Our Case Number: ACP-323972-25

Re: Public realm and community infrastructure project on lands in Ardee, Co. Louth
Ardee, Co. Louth

Re: Notification under Section 175 of the Planning and Development Act 2001 as amended.

Re: Public Realm and Community Infrastructure Project on lands in Ardee, County Louth

**HDC 1256 500 02**

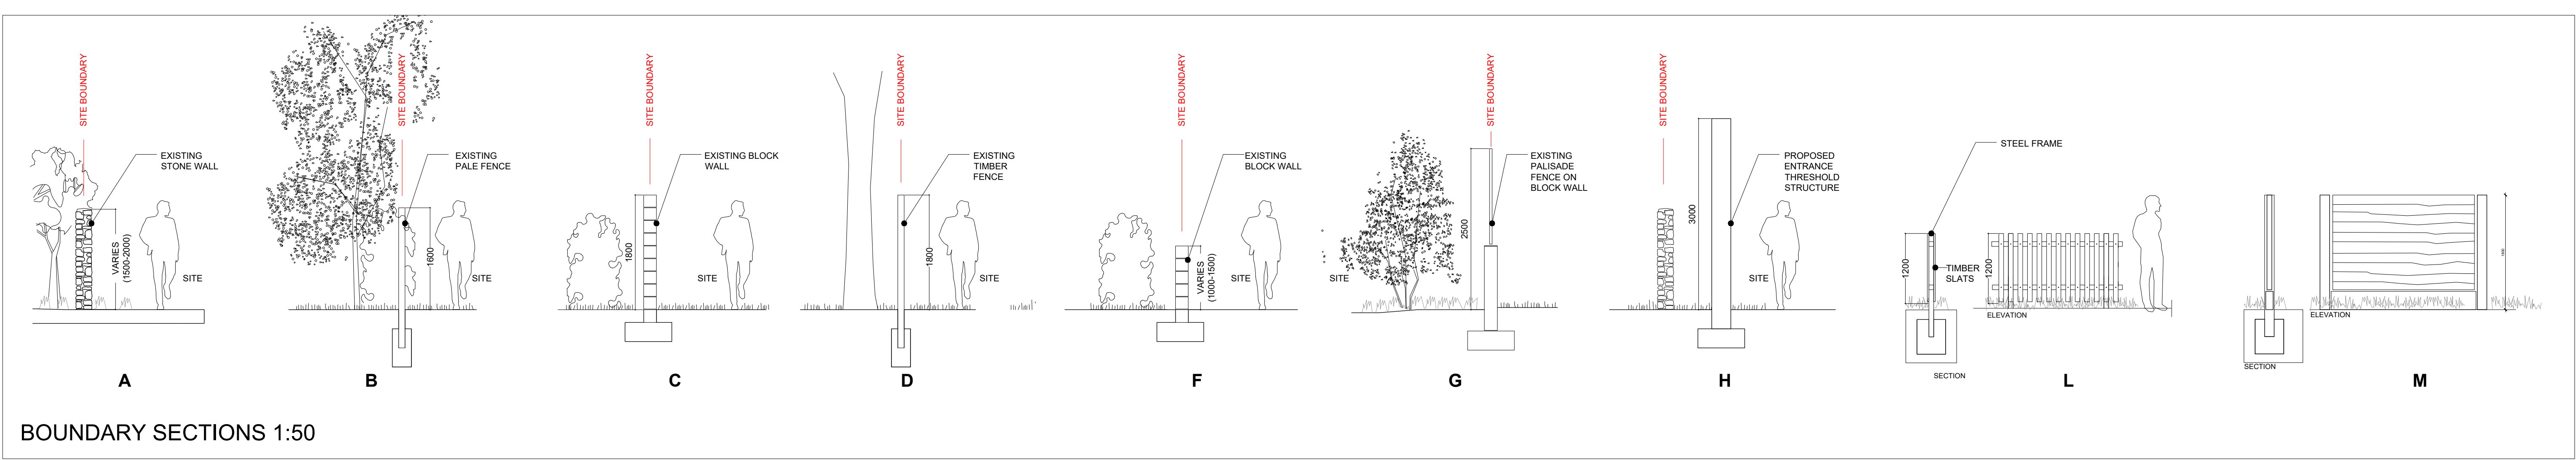
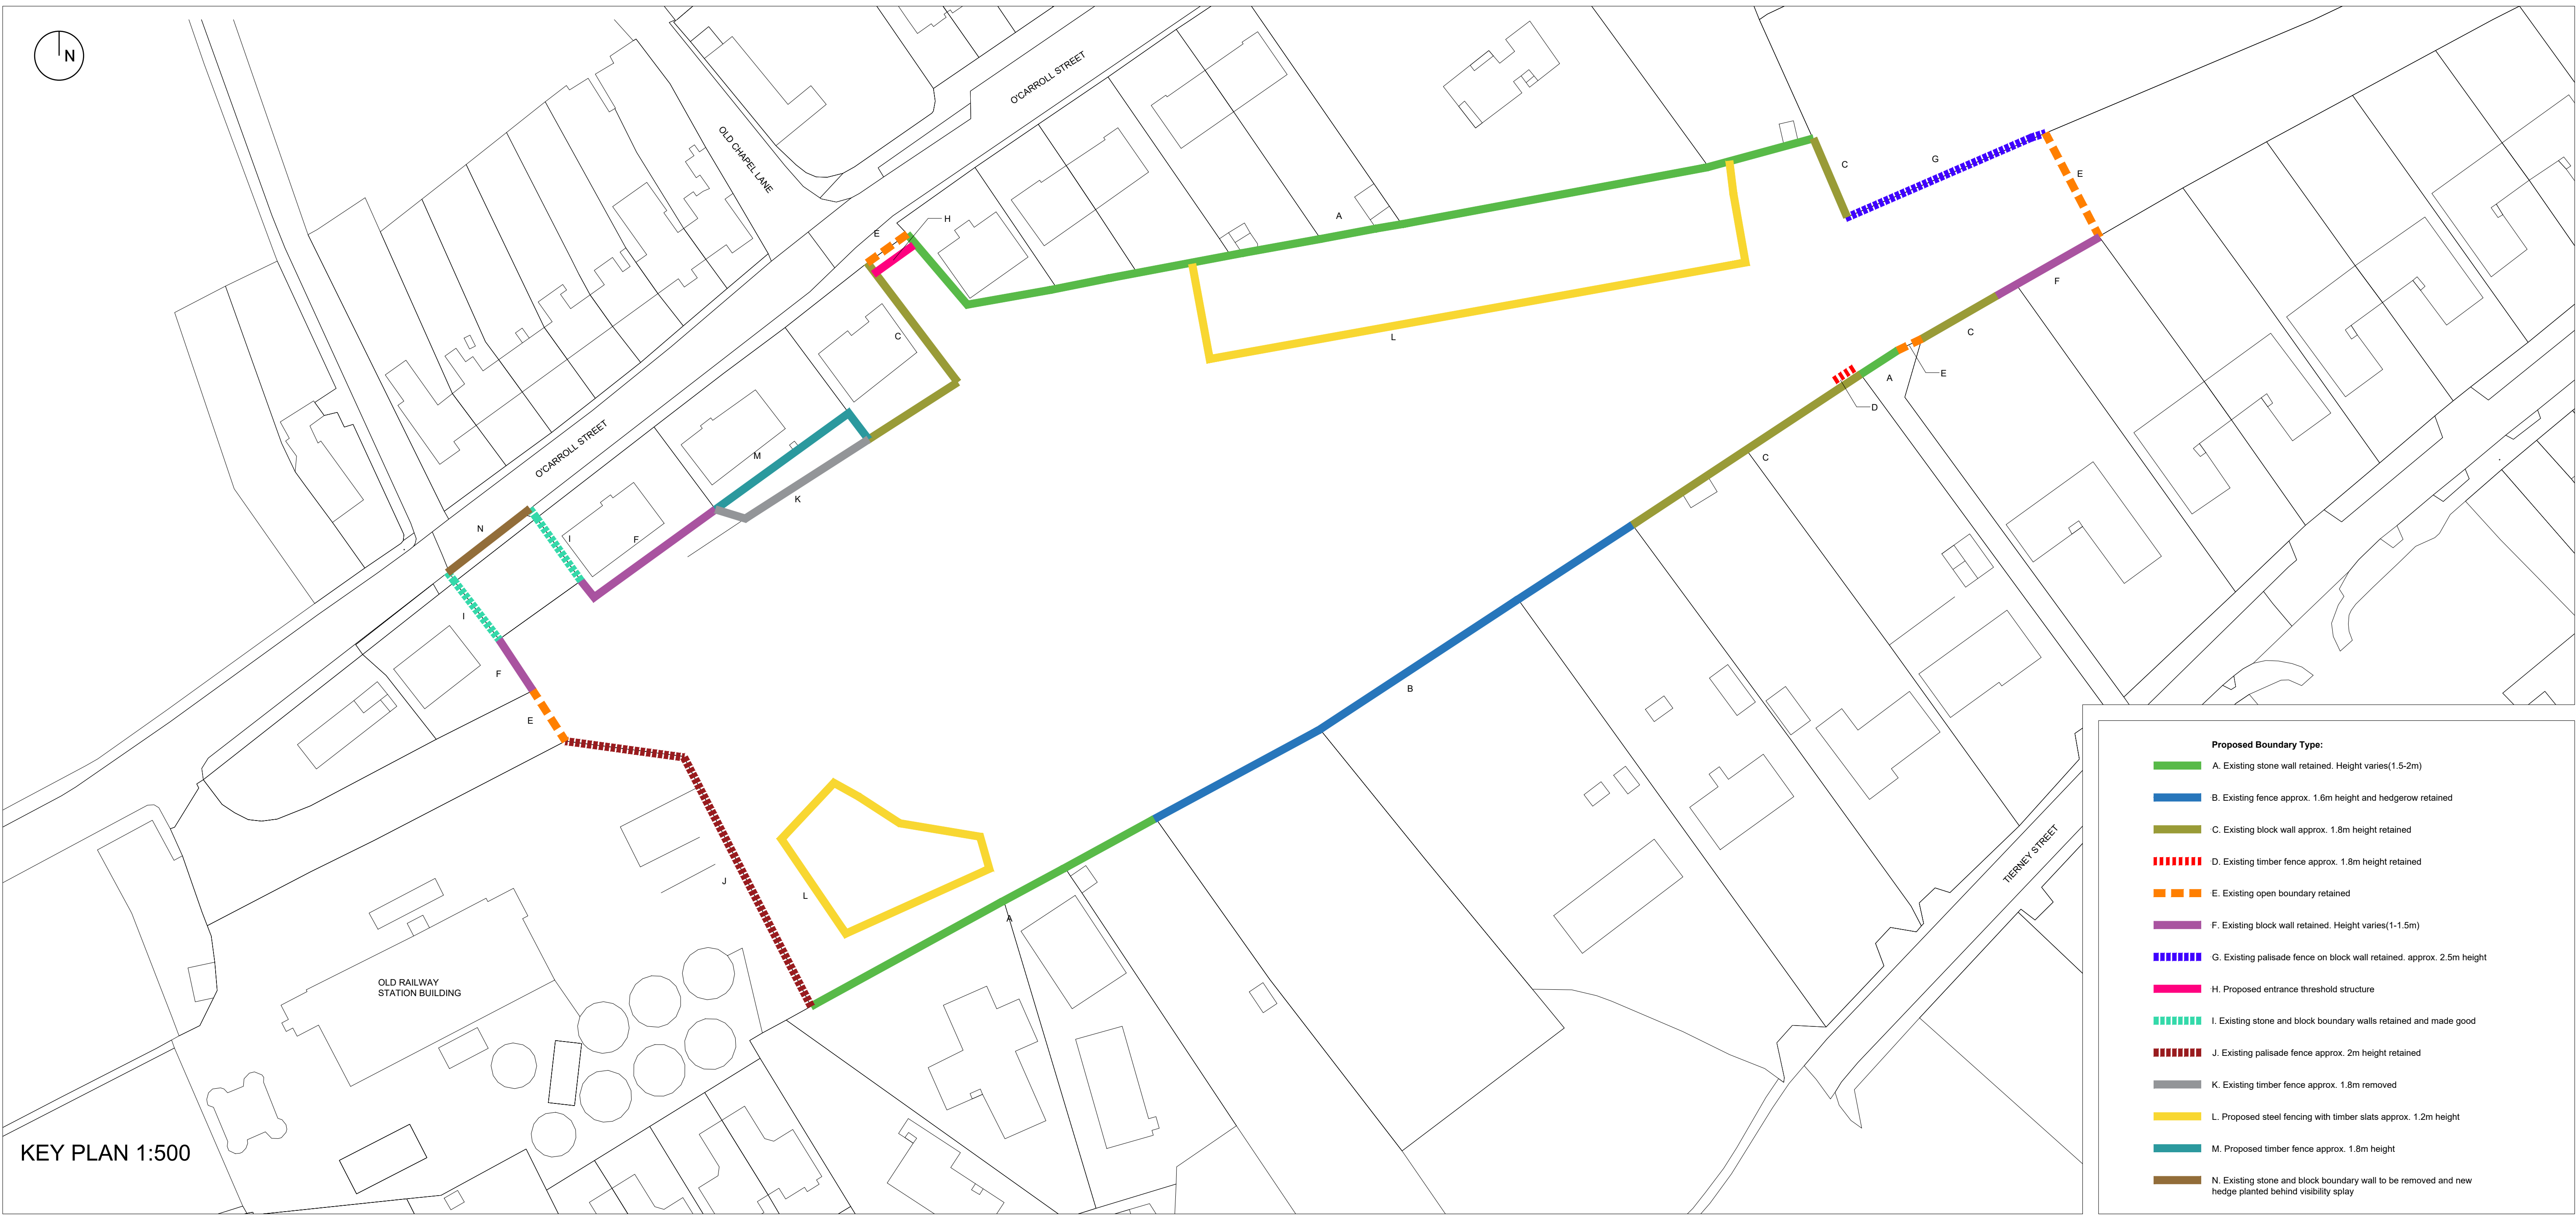
The Department observes that the landscaping proposals for the new community park to be established on the Old Railway Lands off O'Carroll Street as part of this proposed project include the sowing of yellow rattle and other wildflower seeds, with the aim of enhancing biodiversity. It being intended that the semi-parasitic yellow rattle will reduce the dominance of grass species in the vegetation presently occurring in this area and allow a wildflower meadow to become established from the other seeds to be sown in the area from a commercially sourced seed mixture. But it should be noted that the All-Ireland Pollinator Plan advises against planting wildflower seed outside a garden setting. To clarify, the following points are taken from the Position Paper by the Dublin Naturalists' Field Club entitled '*The case against 'Wildflower' seed mixtures*' which is endorsed by the All-Ireland Pollinator Plan and reproduced on their website¹.

In the present case, while it would therefore be acceptable from a nature conservation perspective to sow yellow rattle on the Old Railway Lands as proposed if sourced from a local wild population of this species to weaken the dominance of the grass species occurring there, the Department recommends against sowing other wildflower seeds in this area unless they can be similarly sourced from local populations of wildflower species. If seeds from local wildflower populations are not available, it should be possible to establish wildflower meadows within the Old Railway Lands by allowing herbaceous species to become established from the soil seed bank and natural dispersal under an appropriate mowing regime.

That the proposed sowing of commercially sourced 'wildflowers' should be omitted from the Landscaping Plan for the new community park to be established on the Old Railway Lands as part of proposed development, and wildflower meadows should instead be established in the park either by sowing seeds collected locally from wildflower species populations, or by promoting the germination of wildflowers from the existing site soil seed bank and natural dispersal under an appropriate mowing regime.

Proposed 3m wide
Woodland Walk

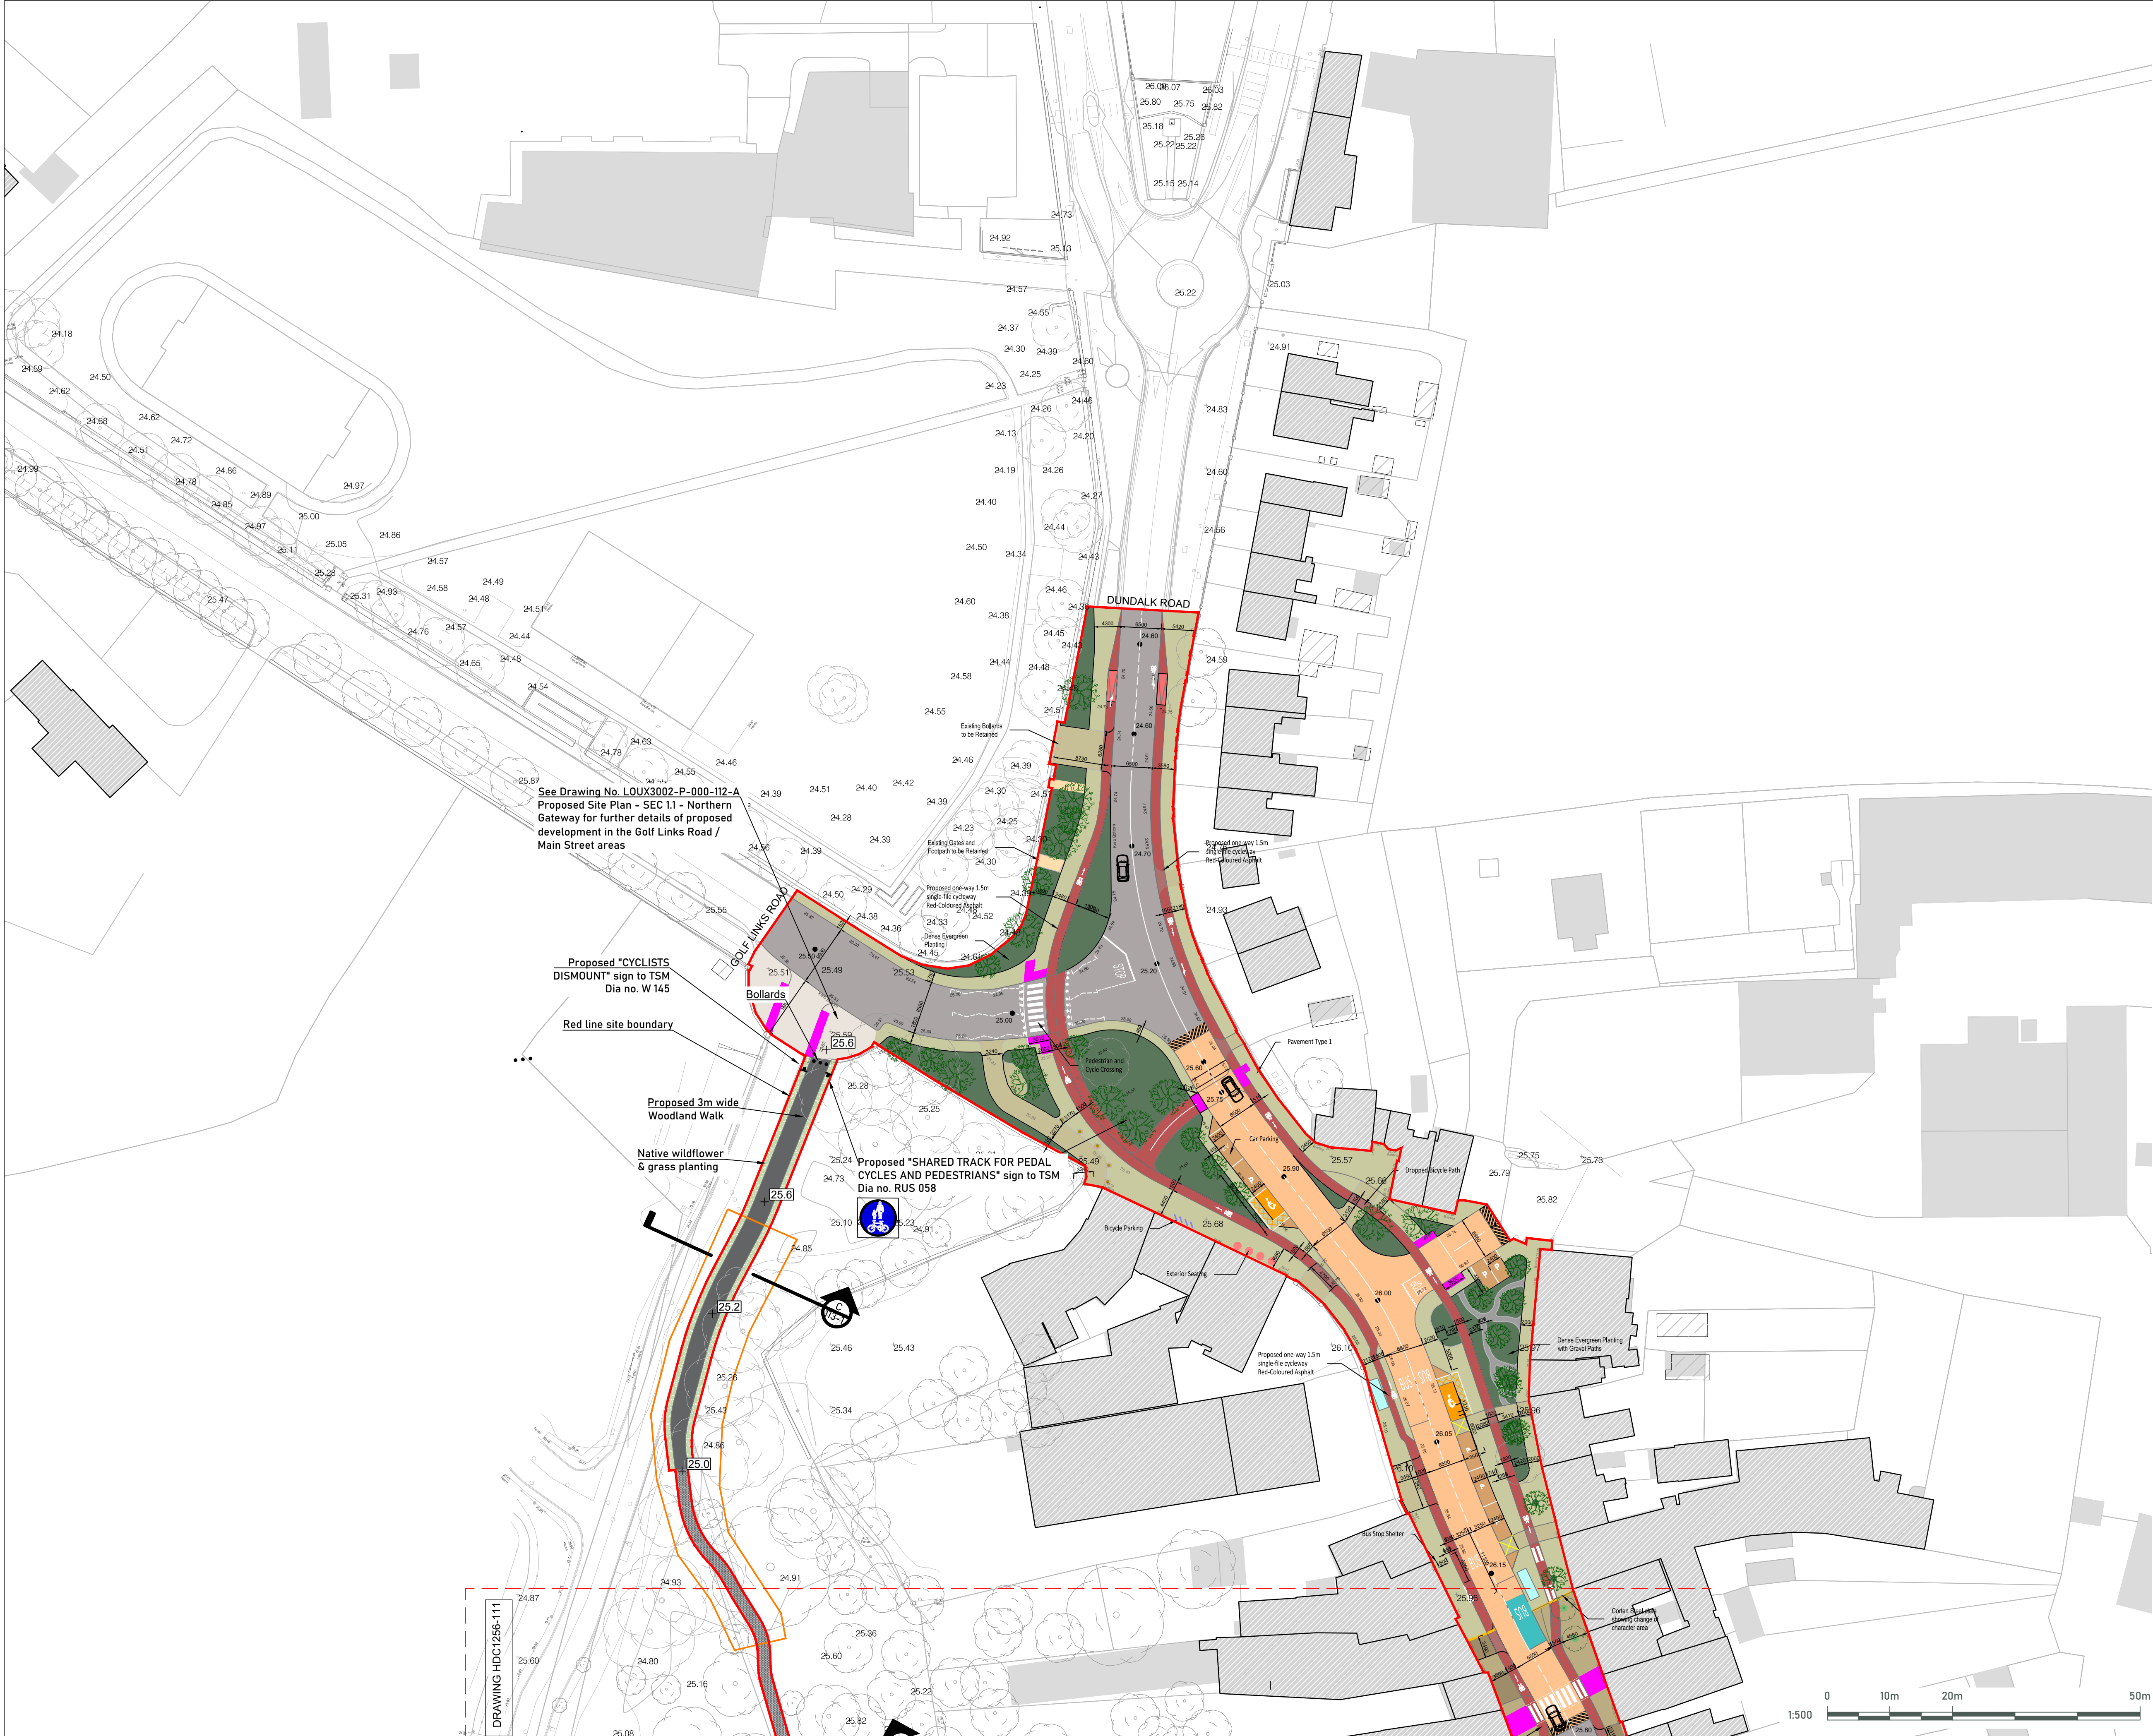
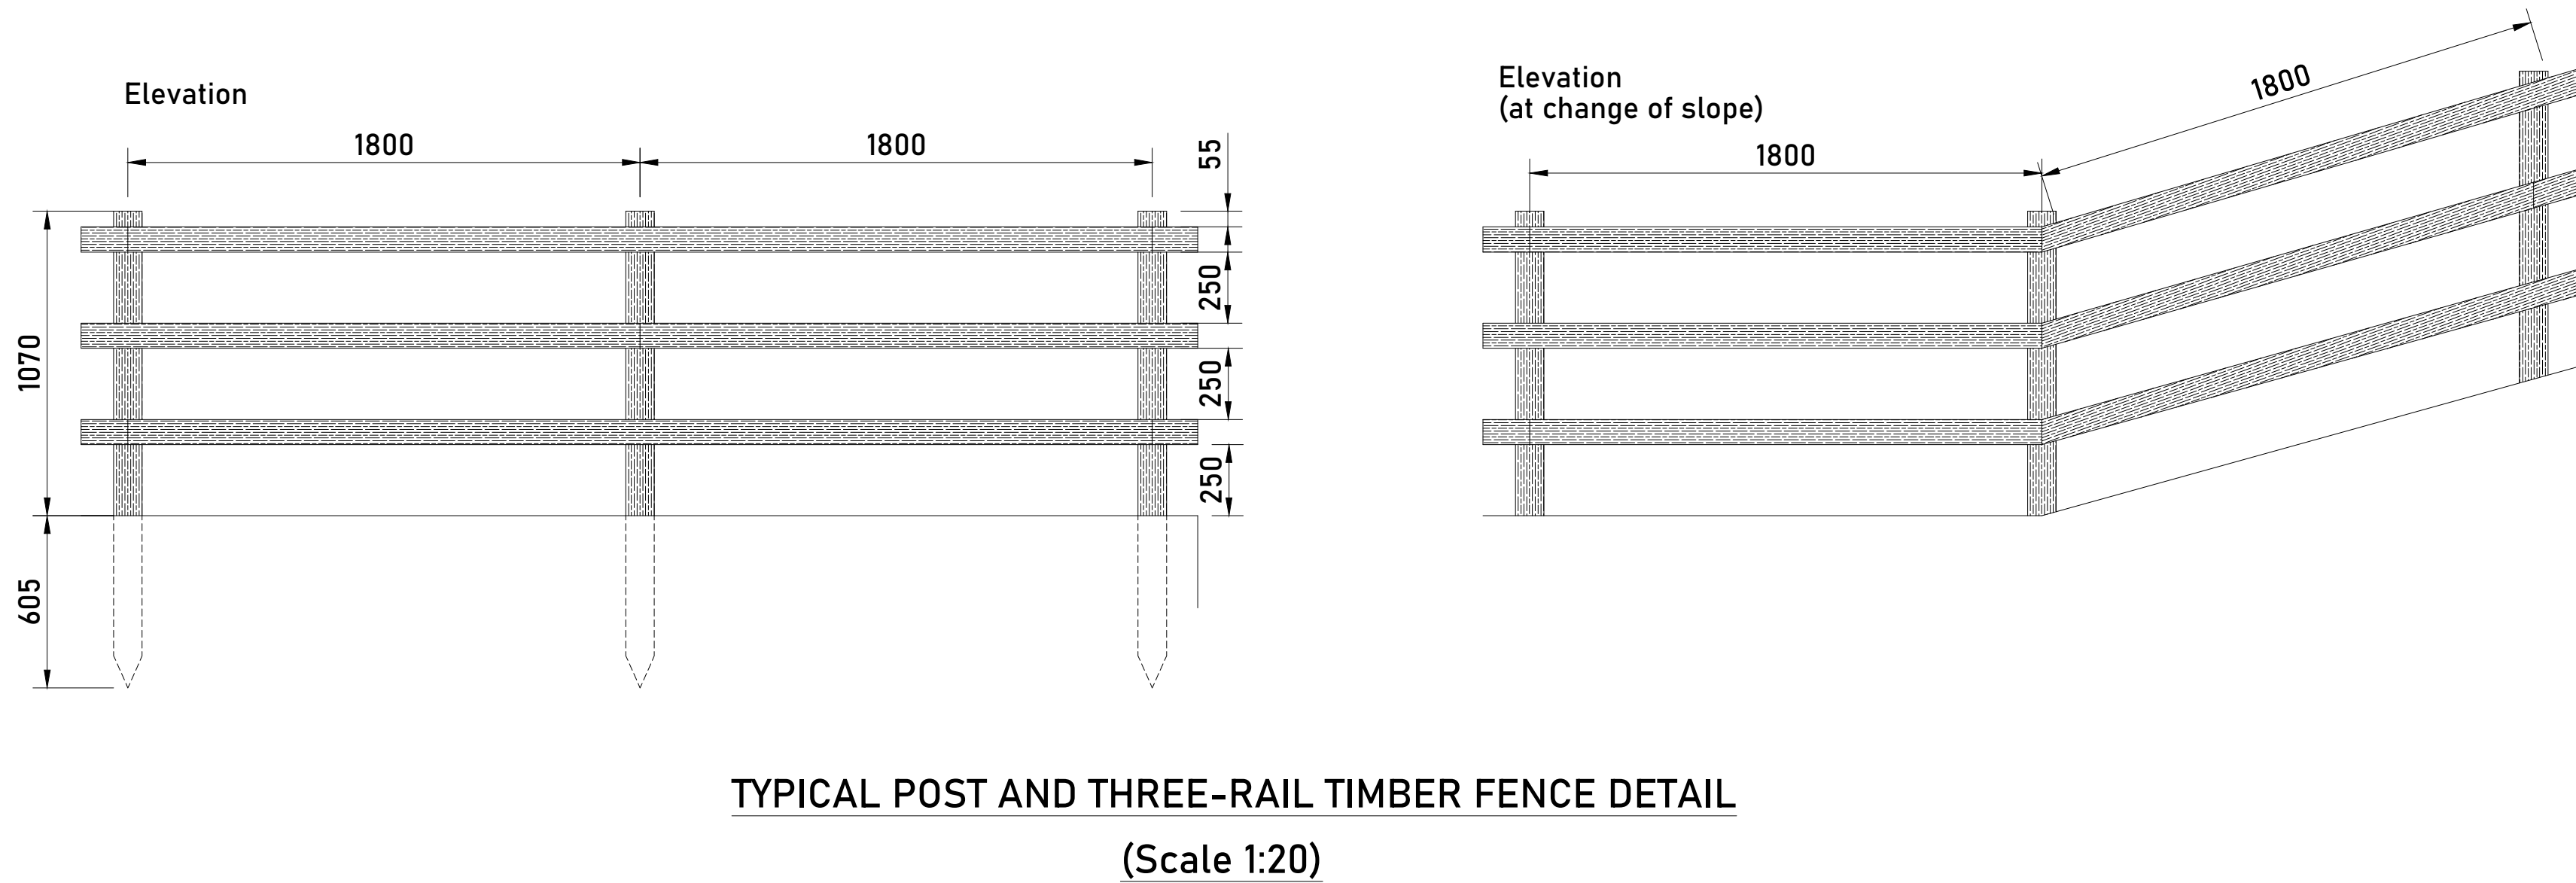
It is noted that the proposed development is located within the historic town of Ardee Recorded Monument historic town of Ardee (LH017-101) and that the proposed woodland walk is located along the line of the Town's Defences Recorded Monument LH017-101001-: Town defences both of which are subject to statutory protection in the Record of Monuments and Places, established under Section 12 of the National Monuments (Amendment) Act 1994. Given the extent and location of the proposed development it could impact on subsurface archaeological remains.

1. All ground works associated with the proposed development shall be monitored under licence by a suitably qualified Archaeologist. The Archaeologist shall also carry out a programme of Test Excavations prior to any groundworks along the line of the proposed woodland walk at locations chosen by the Archaeologist in relation to Recorded Monument LH017-101001- : Town defences (licensed under the National Monuments Acts 1930-2004), having consulted the site drawings and the National Monuments Service.
